Re: Resubmitted Planning Permission for R.O.B.E.

Thank you for the opportunity for making a public submission regarding the potential R.O.B.E. development at Wagga Wagga. This development will take place in the Bomen region.

I have several objections to the planning resubmission.

Figure 15: Site Plan Including the Proposed Wastewater Storage Dam (east of plant)

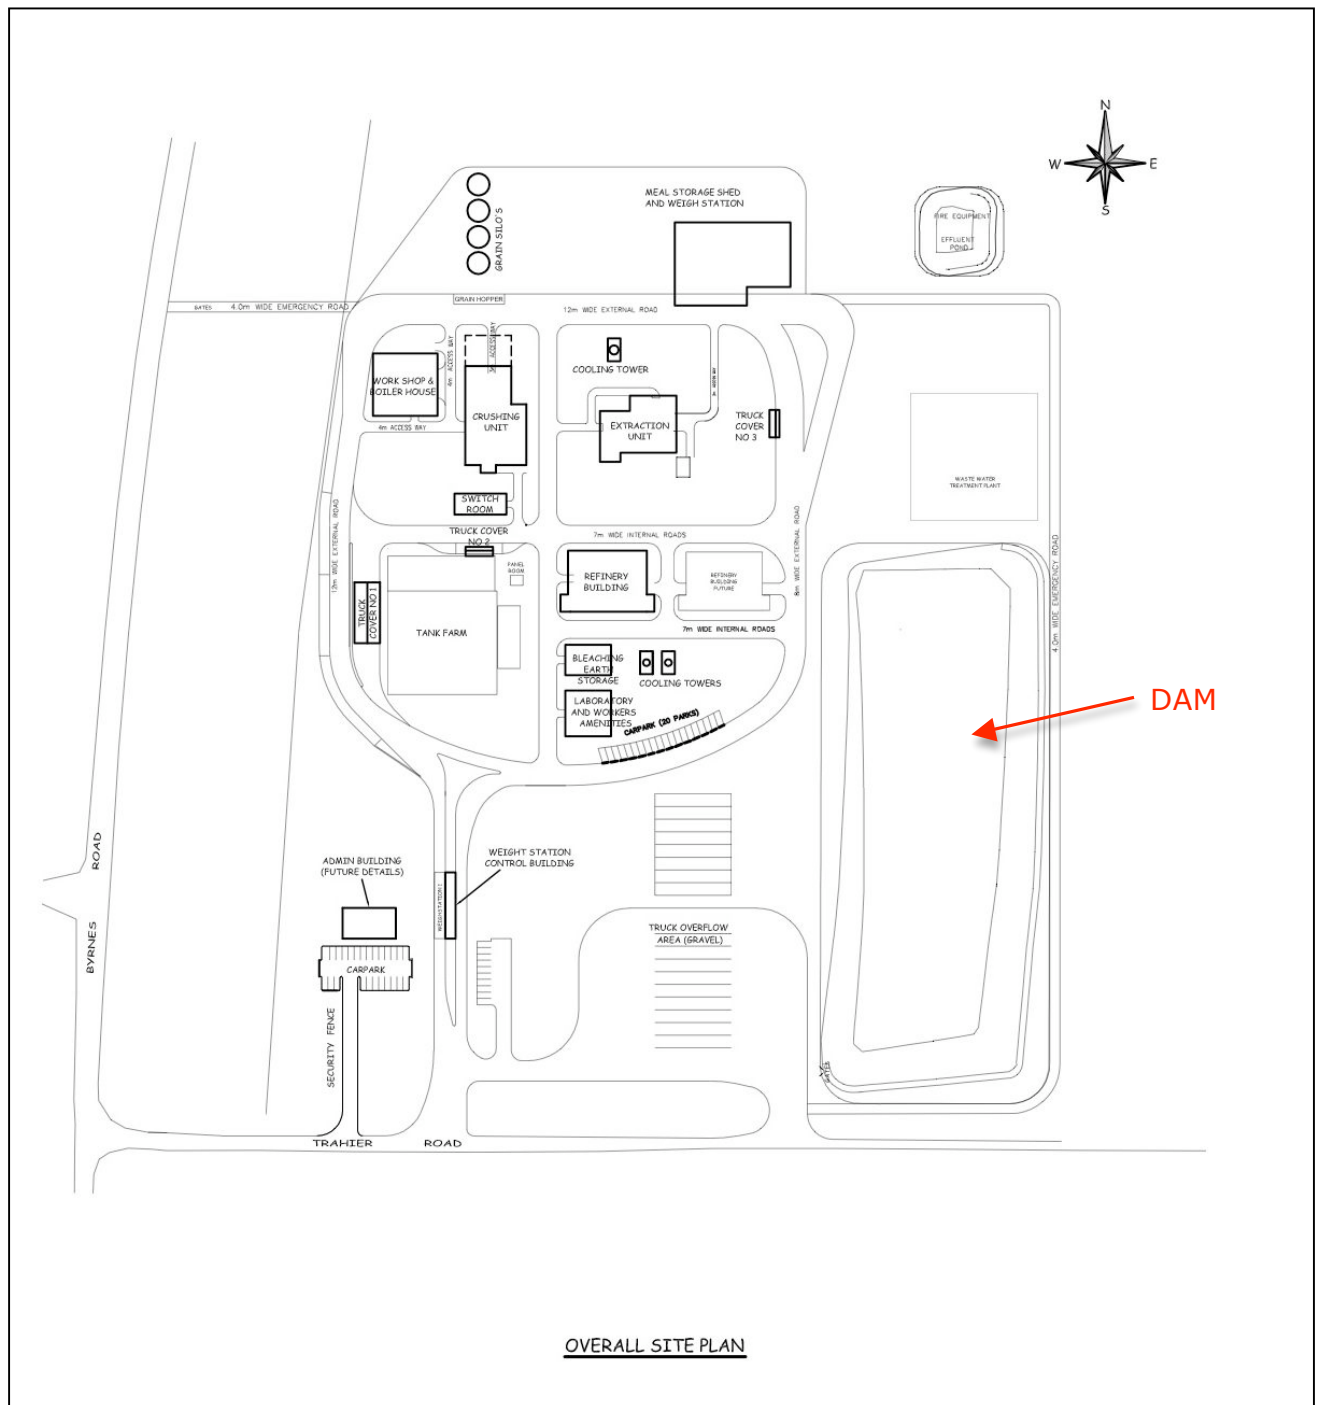
Thirdly, water is a significant issue in this development. The resubmission suggests that water usage will exceed 174 mega litres a year. There will be construction for a 40 mega litre dam only. Therefore the shortfall will have to be made out of local water supplies. Until we had recent decent rain the water table level in Wagga had fallen to catastrophic levels. Further west of Wagga towns are importing water. I do not think that water usage of this scale is sustainable without provision for further water salvage.

Figure 28: Amended Elevations for the IOPP (without the Biodiesel component)

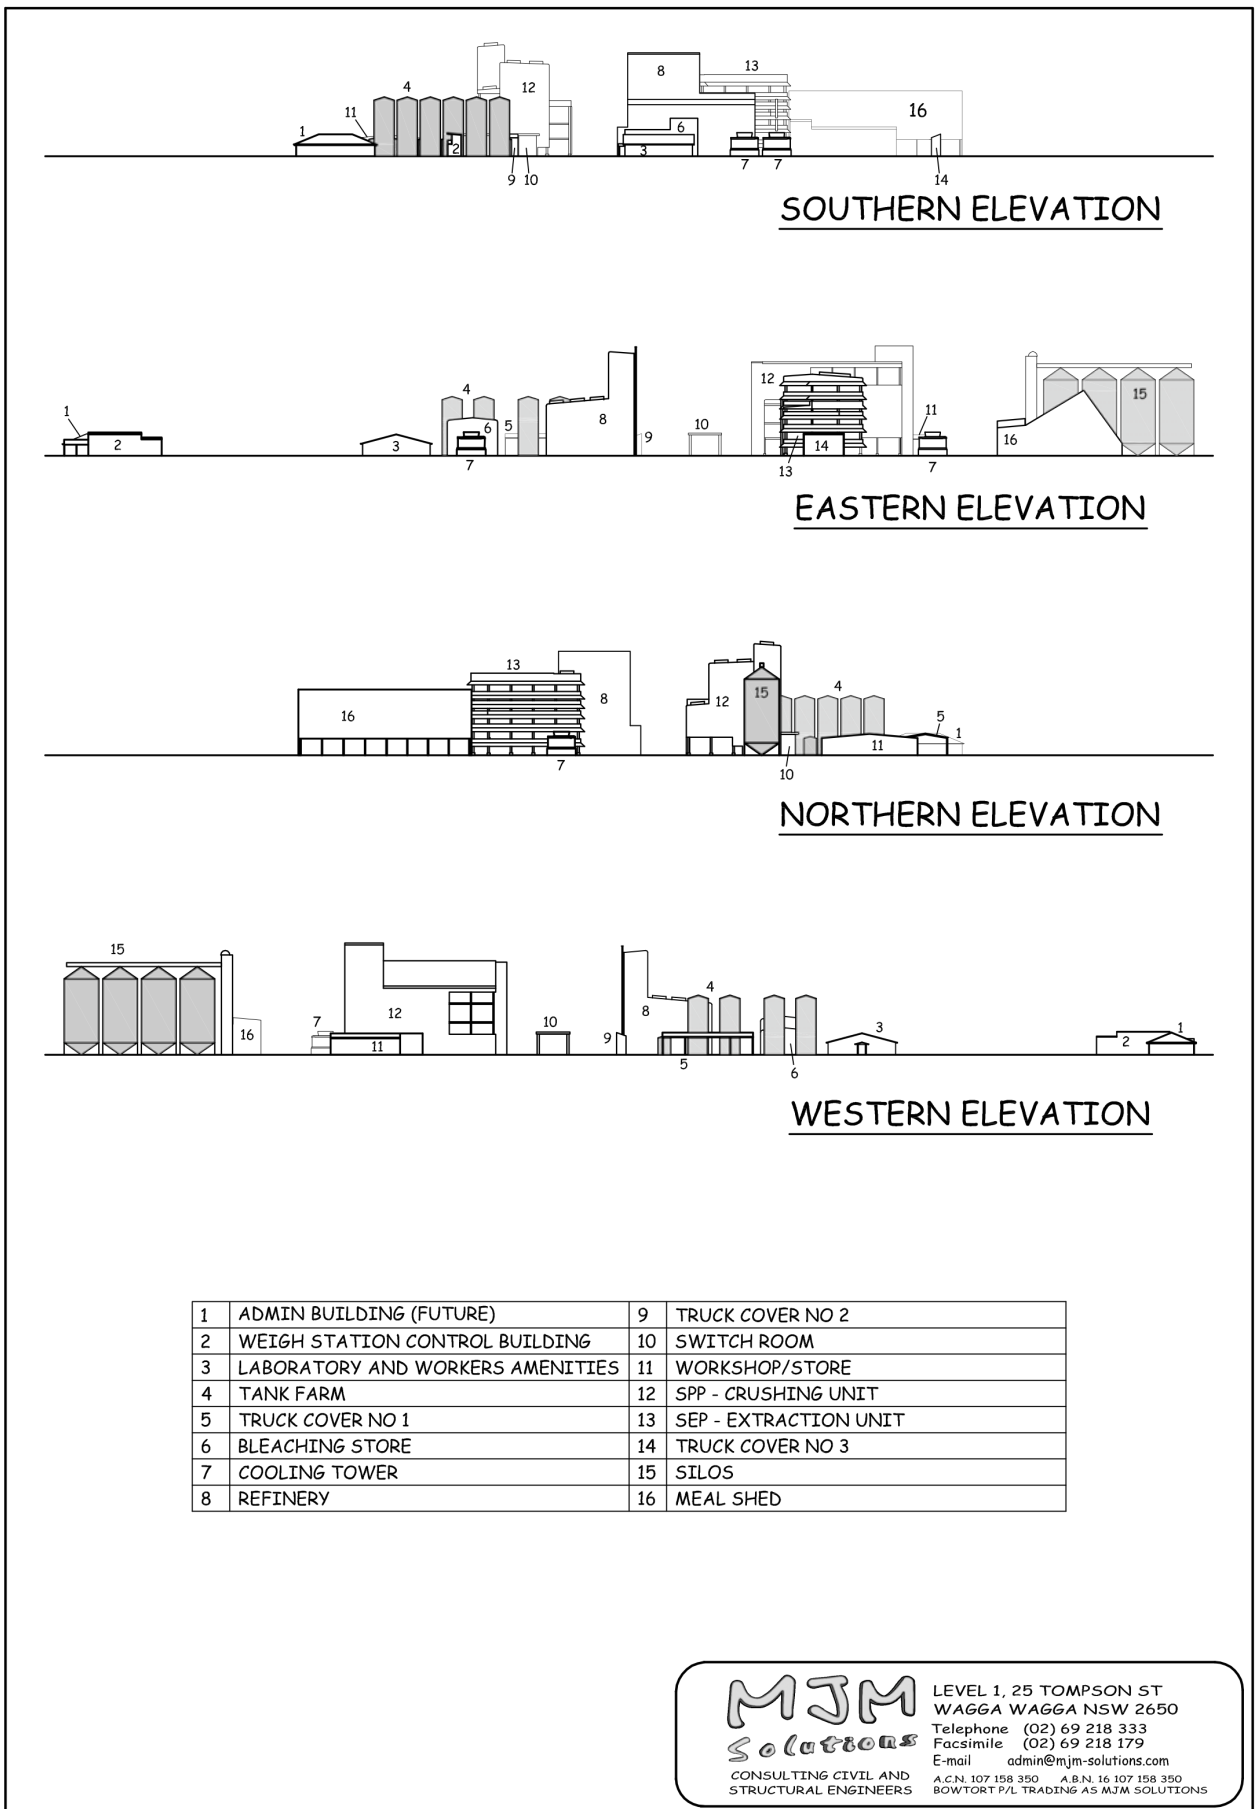
In the initial documentation there was to be one 27 metre high silo. There will now be in excess of seven buildings that are more than 27 metres high. This represents a significant visual impact for a massive area of north Wagga. These buildings will be able to be seen far and wide. There is not enough detail in the planning submission to document how this visual impact is to be mitigated.
